Extension to driveway to front & widening driveway gate. This application affects the character & appearance of the Craigweil House Conservation Area.

19 Kingsway Aldwick

Thank you for your internet representation made on 8th October 2019 which has been recorded as '**no objection**' with the comments as follows:

Proposed

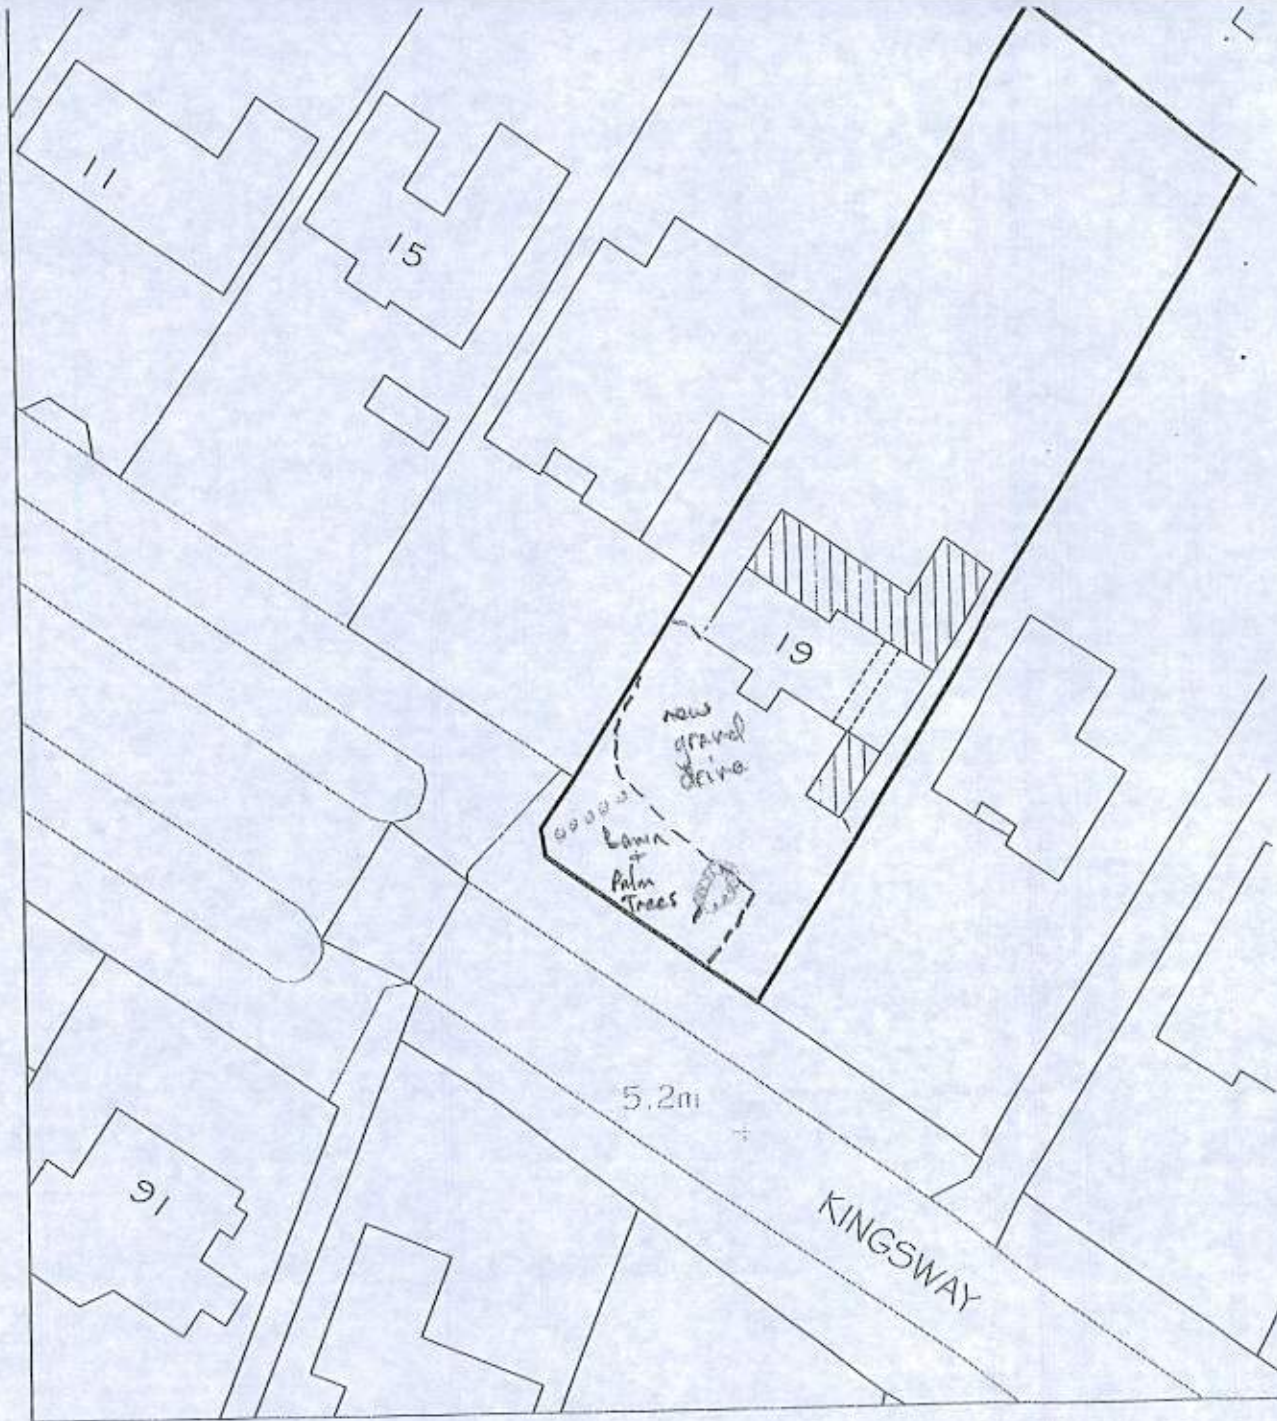
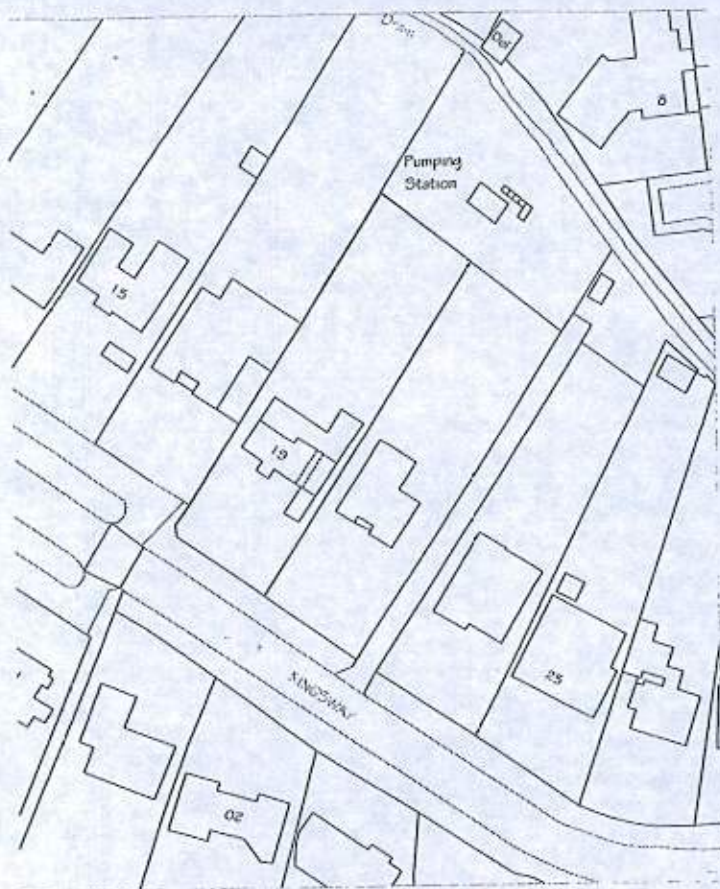
Precise details of the gate and gate piers to be submitted to the Local Planning Officer.
